09117
10 November 2011

**SECTION 75W MODIFICATION - MP09_0154 (MOD 1)
7 RAILWAY STREET, CHATSWOOD**

LEVEL 38

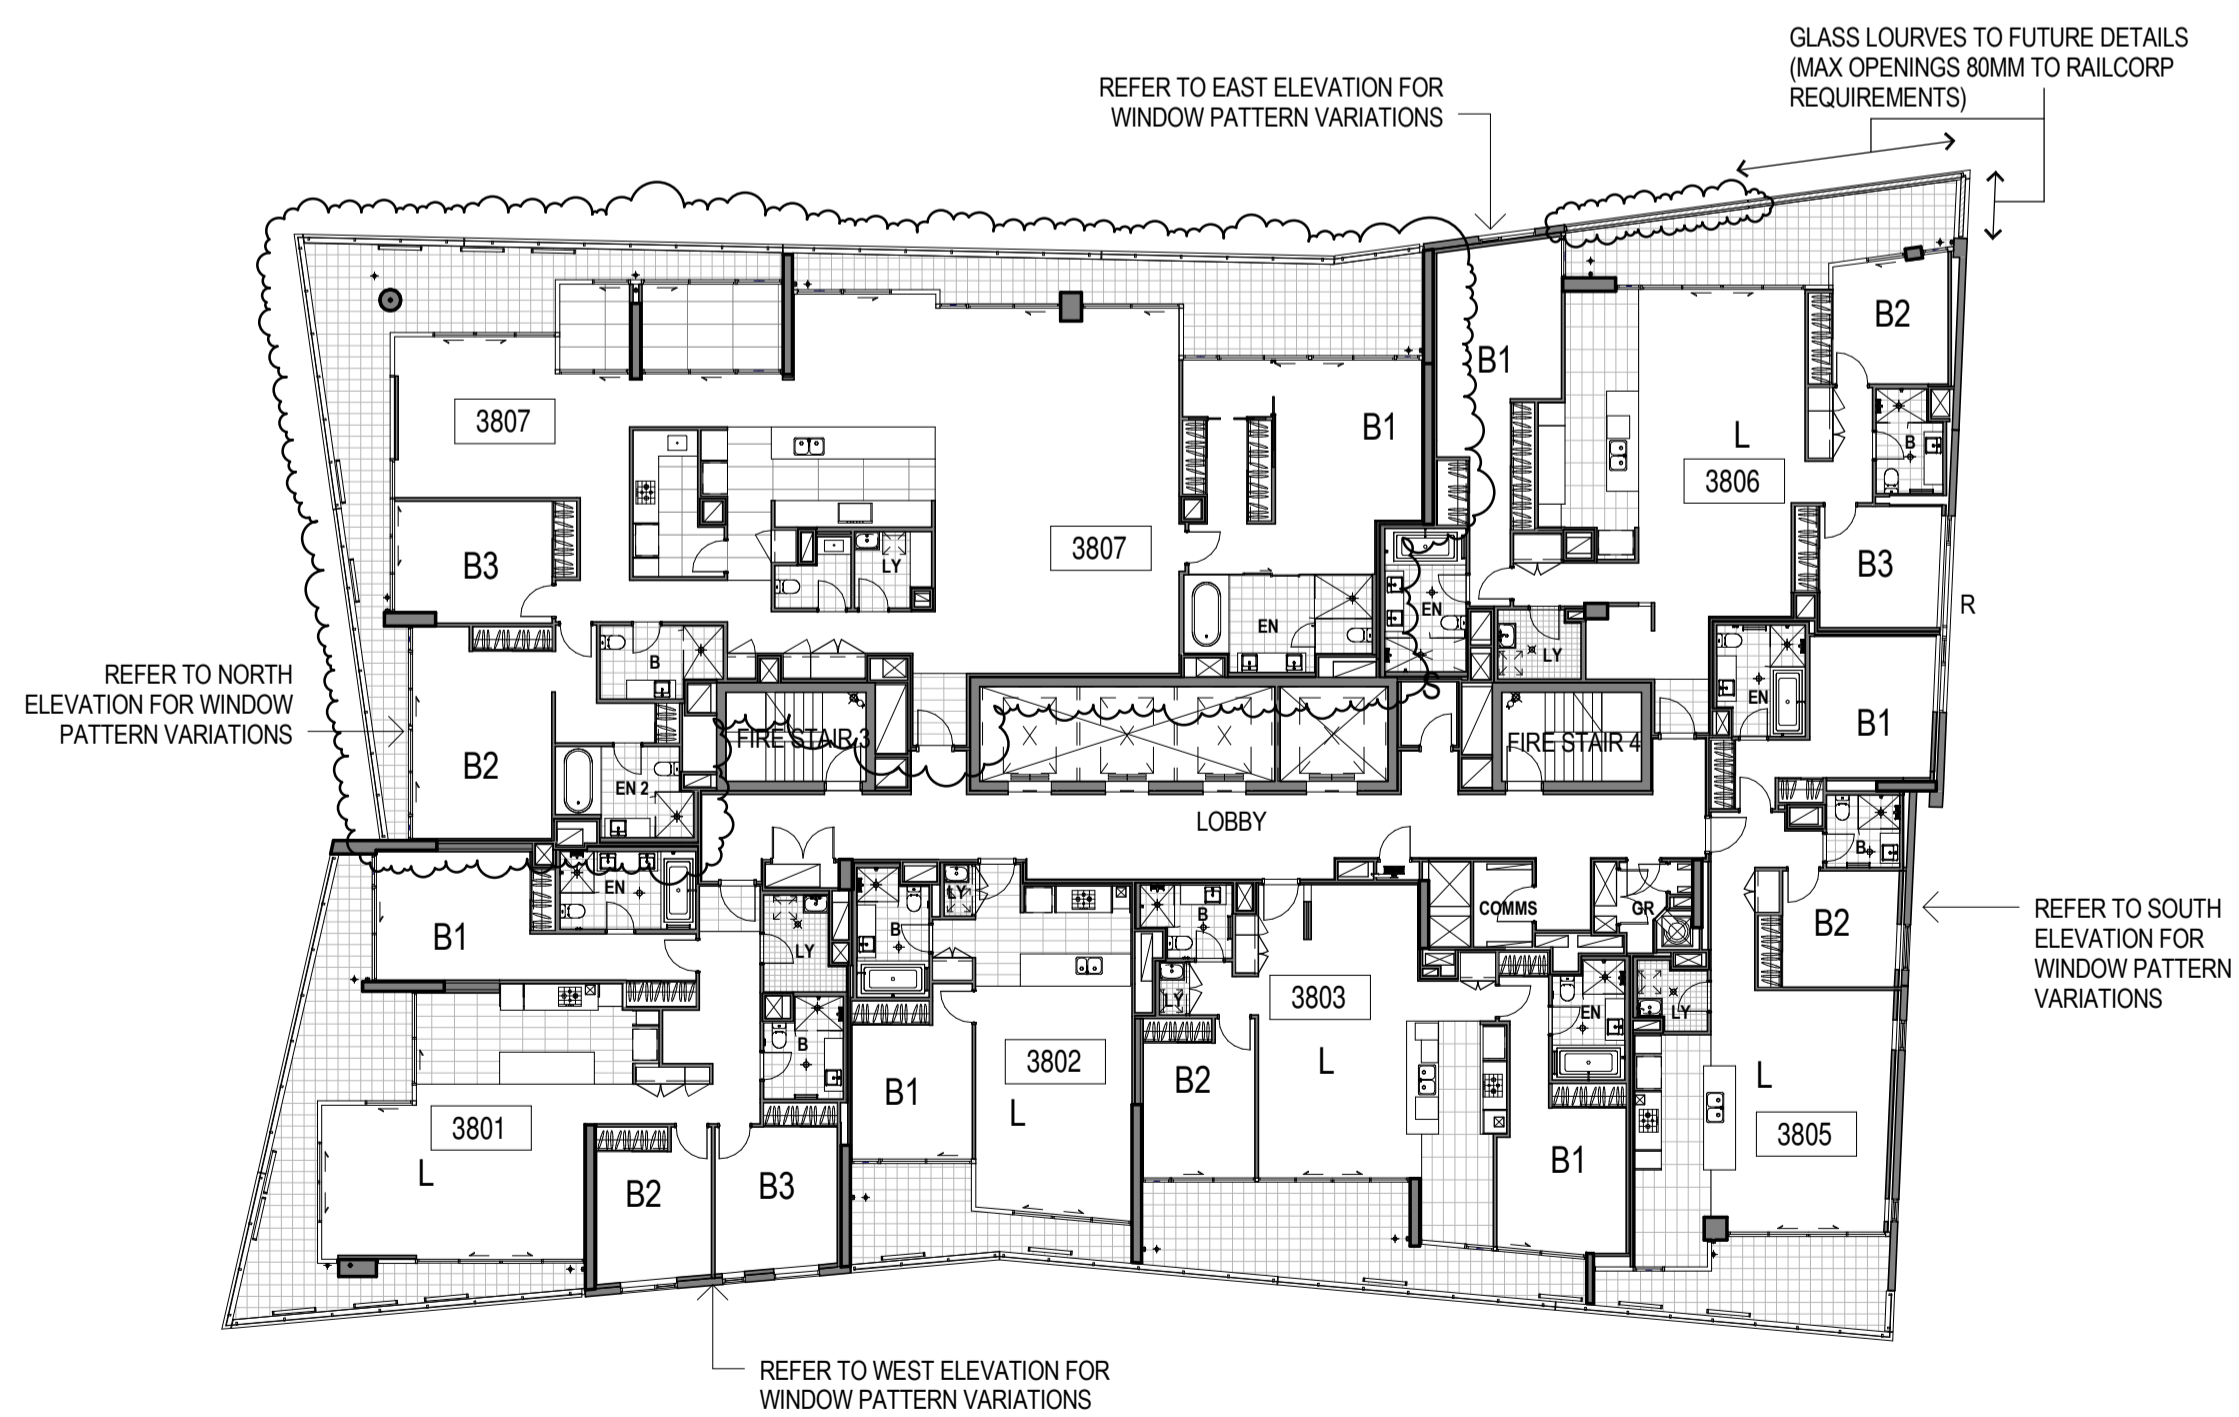
One purchaser has bought two units on Level 38 of the building and wishes to amalgamate the lots into one apartment. In order to reflect this design change the level 38 floor plan and the residential strata plans have been updated. The design changes are internal only and not result in any changes to the facade. The revised architectural and strata plans are appended at **Attachments C and D** respectively.
